Please ask for: Nicola Moore
Email: nicola.moore@arun.gov.uk
Telephone: Ext 37944
Our Ref: A/24/21/PL
Your Ref:
Date: 24th February 2021

Application for Planning Permission

Development: Erection of a temporary sales cabin with 4 parking spaces and associated landscaping.
Location: Land South Of Water Lane Angmering

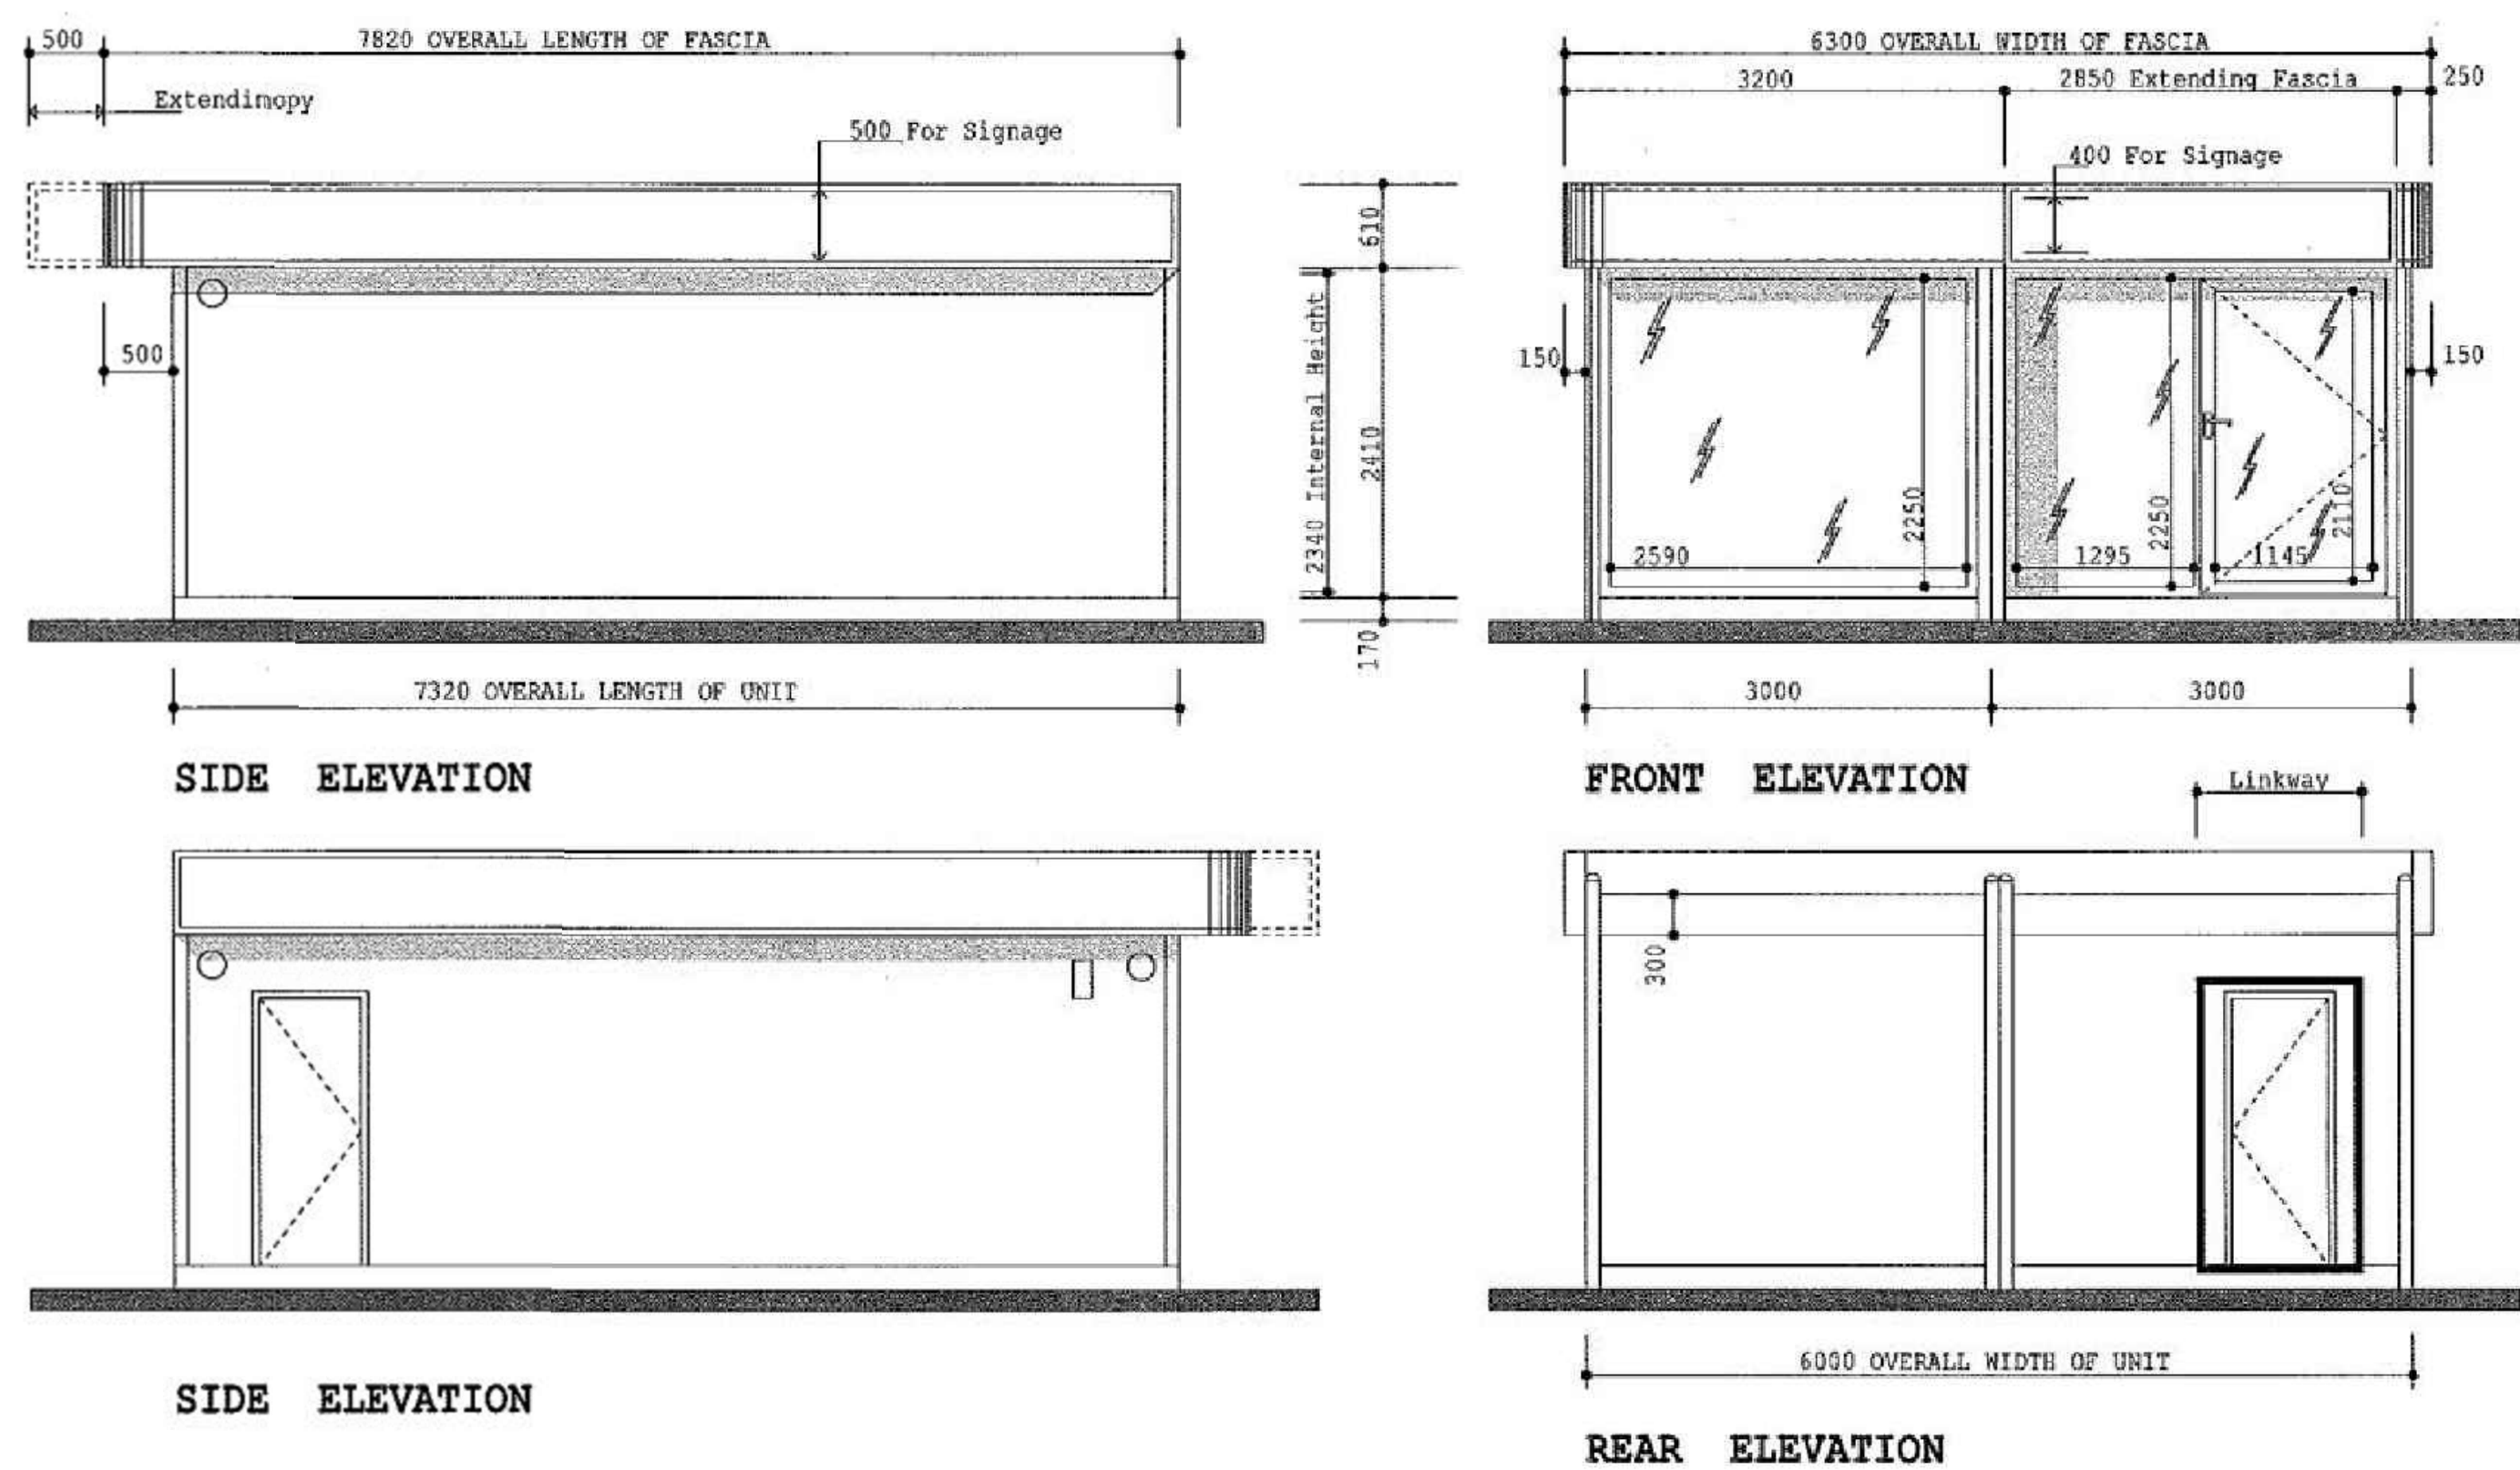
The measurements have been checked at 1:100 and 1:50, but do not scale. Please check the scale, amend accordingly and resubmit.

The measurements have been checked at 1:100 and 1:50, but do not scale. Please check the scale, amend accordingly and resubmit.
